FORD ROAD, ARUNDEL

PLANNING APPLICATION AB/54/22/DOC

SUDS MAINTENANCE STRATEGY COMMENTS

TITLE
SURFACE WATER DRAINAGE MAINTENANCE PLAN

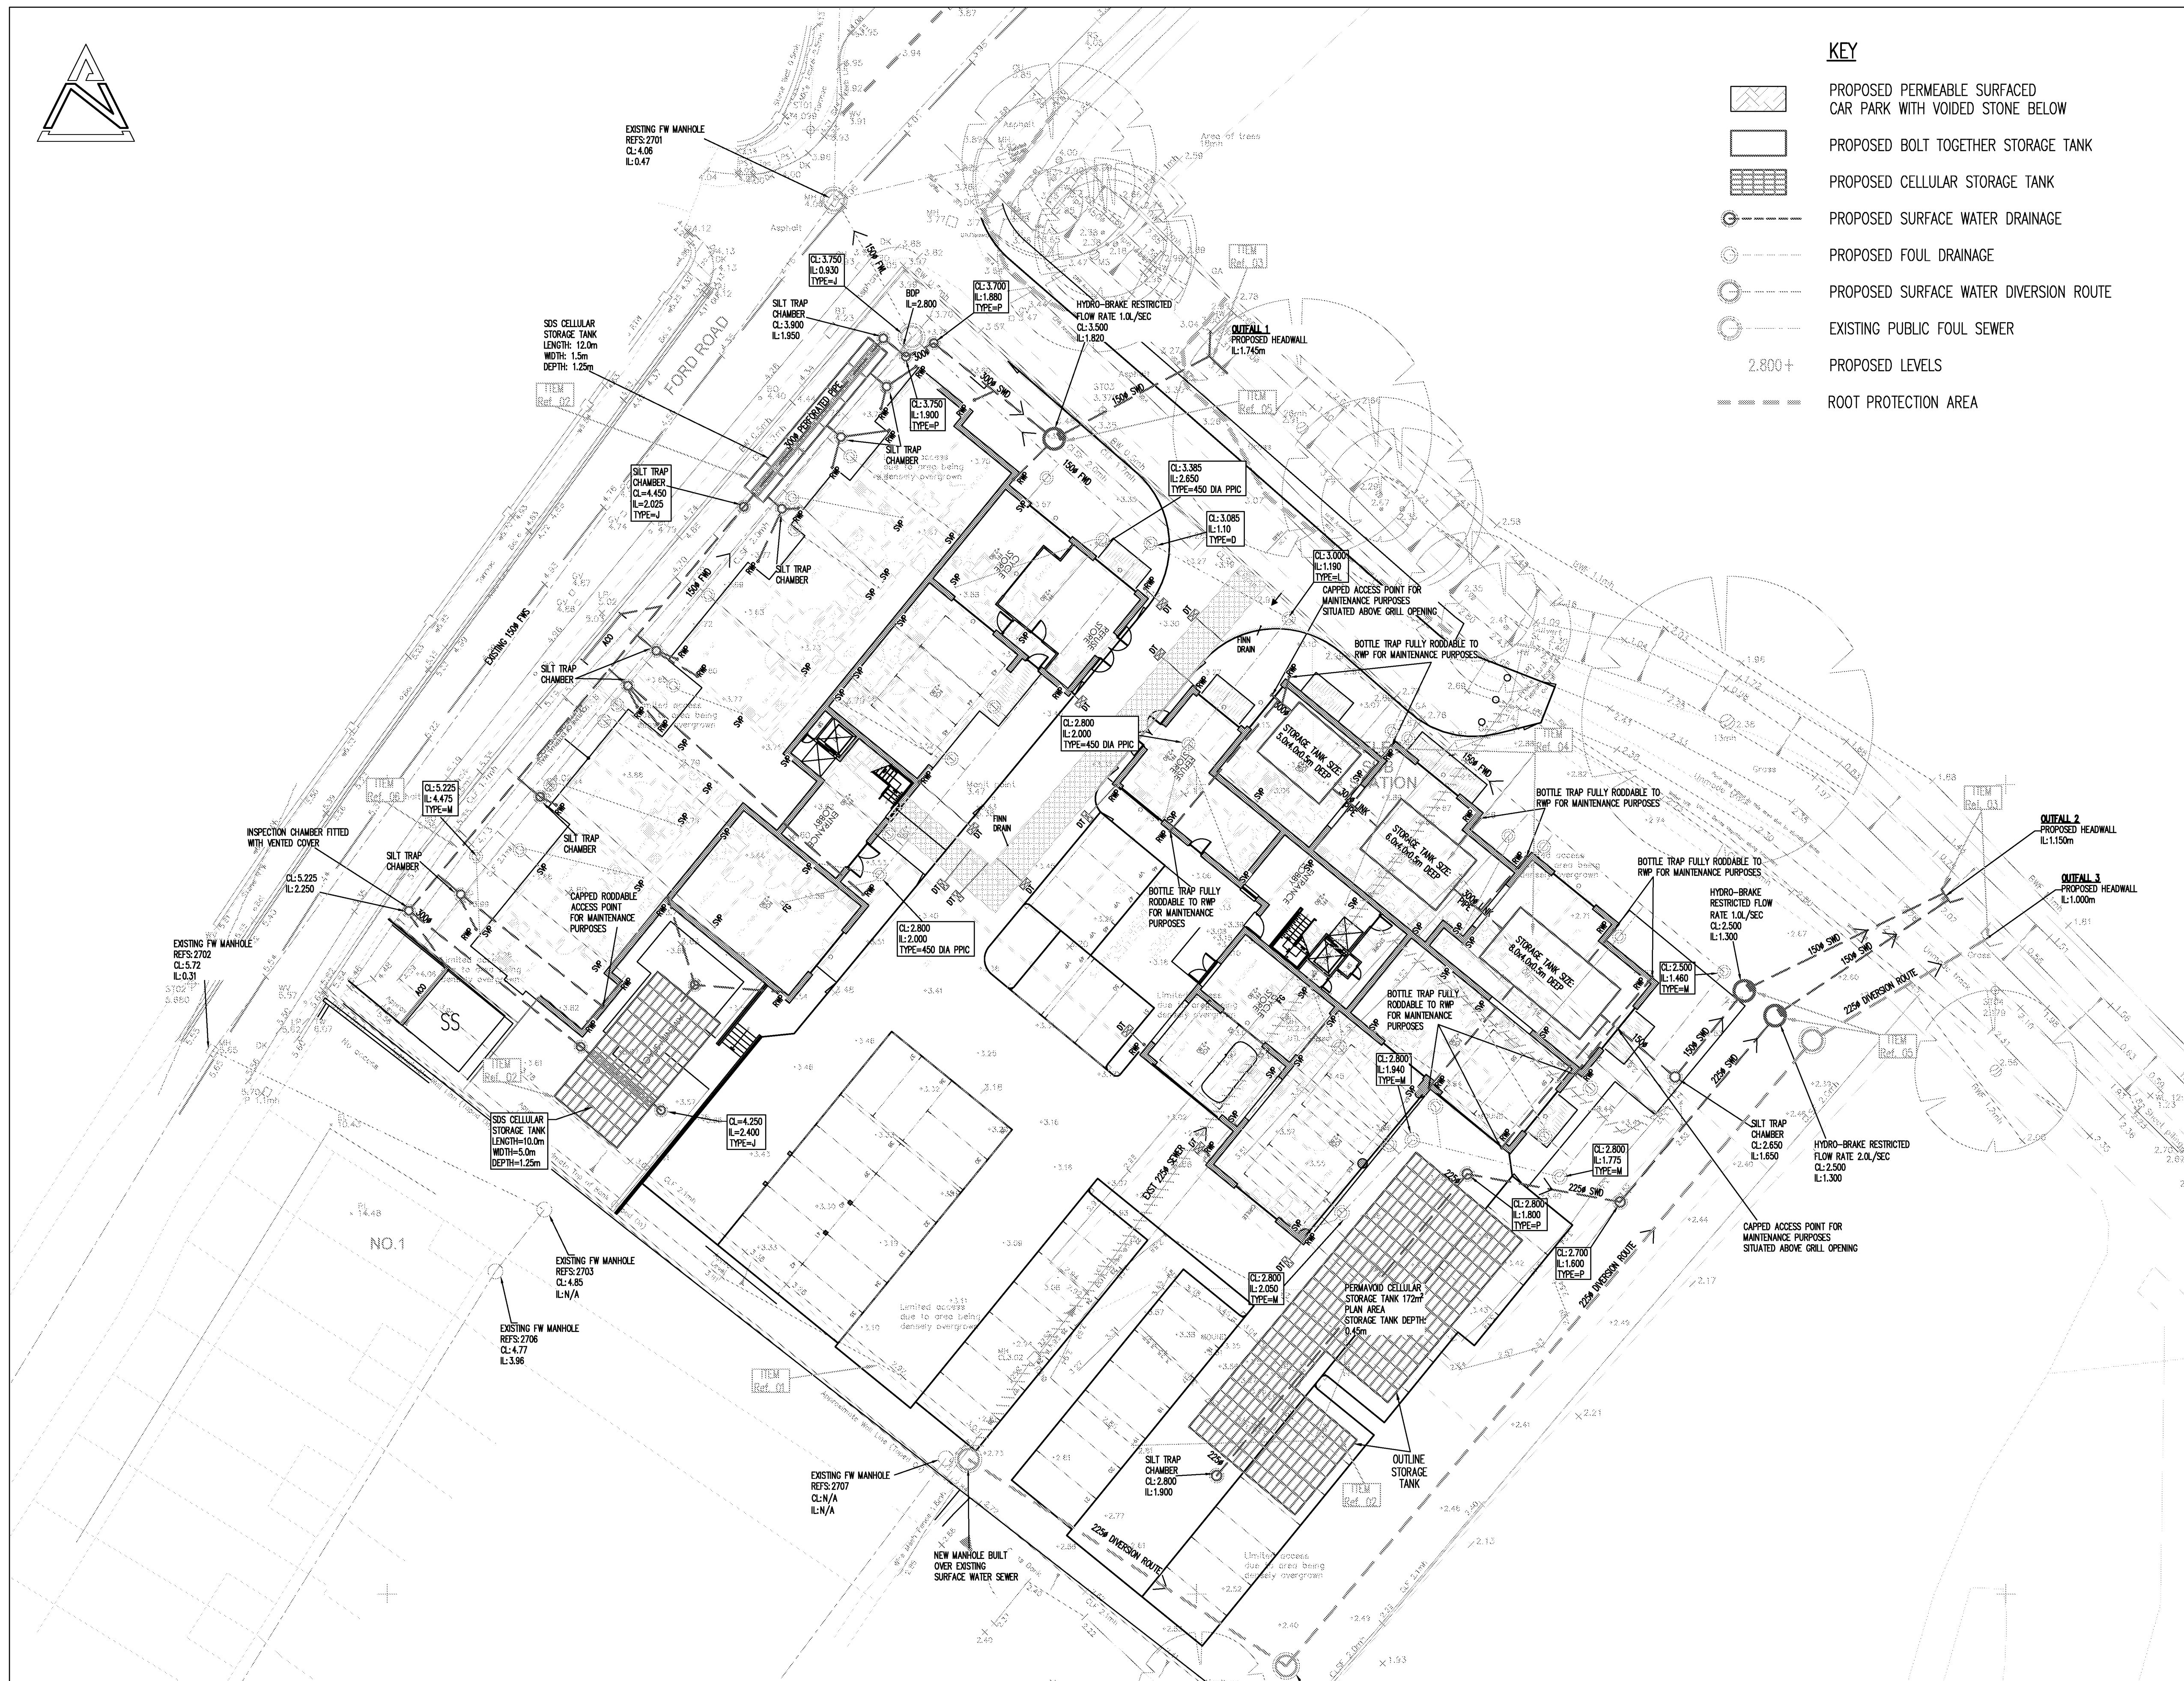
13. The maintenance checklist should be bespoke, any elements that do not appear in the proposed drainage system should be removed from the checklist and any additional maintenance tasks that are required included. For example, specific mention of all flow control devices should be included to minimise the risk of maintenance personnel only inspecting and maintaining one of them. A section of the checklist should also be dedicated to tasks specifically relating to the suspended above ground tank.

The maintenance check list has been revised to only reflect the SUDS items constructed on this particular scheme.
